Application Reference 6/2015/2061/HOUSE

Proposed Development at; 97 The Ridgeway, Cuffley, Potters Bar, EN6 4BG.

Proposal; Erection of two storey rear extension and first floor side extension and alterations to roof.

We are writing to you regarding the Planning Officers draft report on the above application. We would like to make the following observations;

Roof Plan

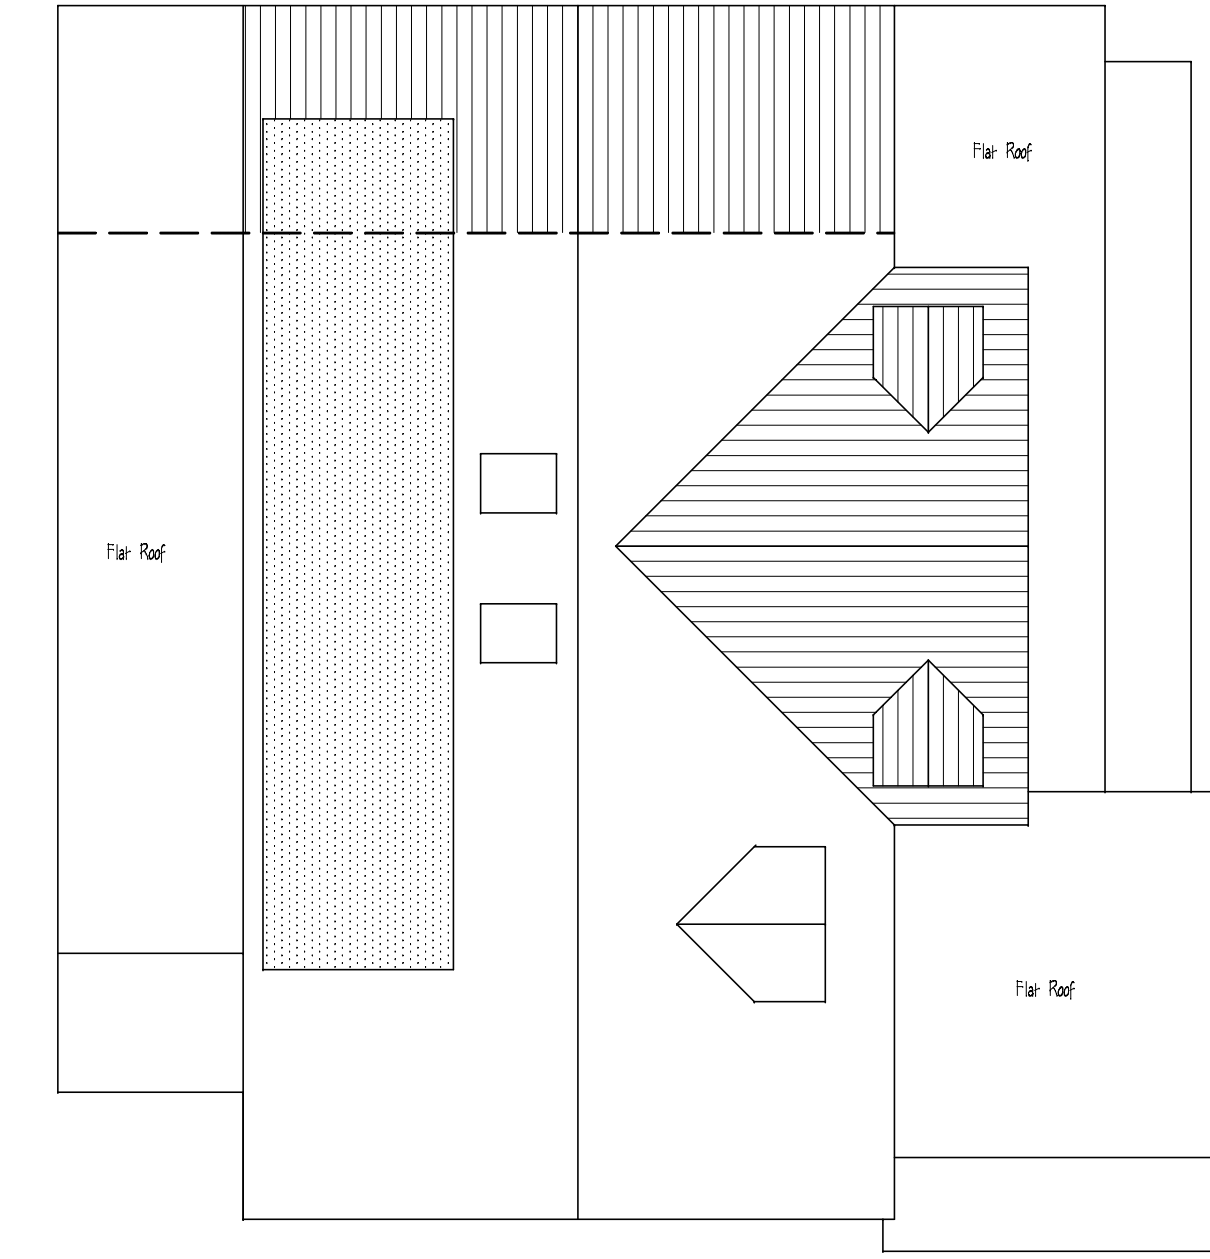
How can a 12M Dormer that will overlap the existing roof on the East side, and be shaped like a square tube sitting on the side of the roof not have a significant visual impact on the character, design and appearance to the property. The report says that it would not significantly change the rural character and appearance of the original building to say that would be misleading the committee. The report says that these extensions would not appear cramped on the site. This plot has already been extended to its boundaries, If the neighbouring properties extended their properties upto their boundary lines, No 97 would become a terraced property.

Rear Elevation (South)

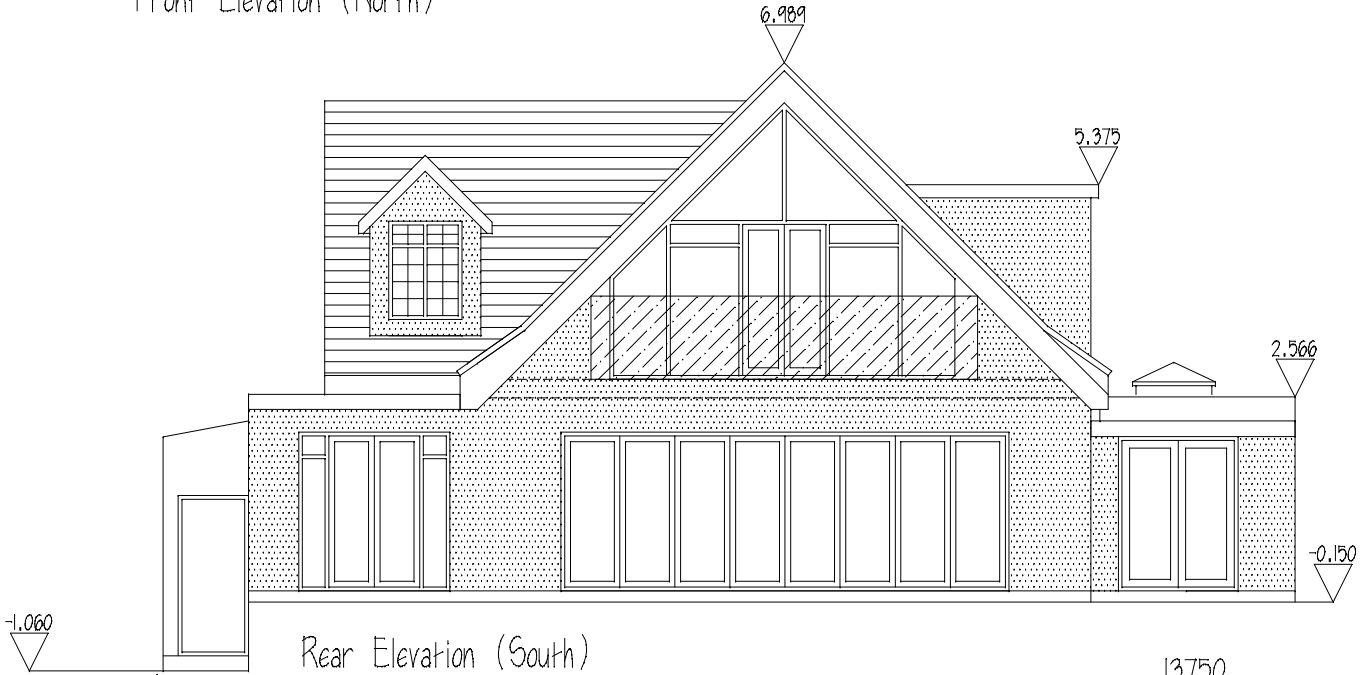
The Juliet balcony will sit at a two storey height and extend beyond the neighbouring properties boundaries. How can there not be a significant increase in the overlooking of neighbouring properties. We cannot find a condition that says the occupants can only look straight down the garden and cannot look left or right when using the Juliet balcony.
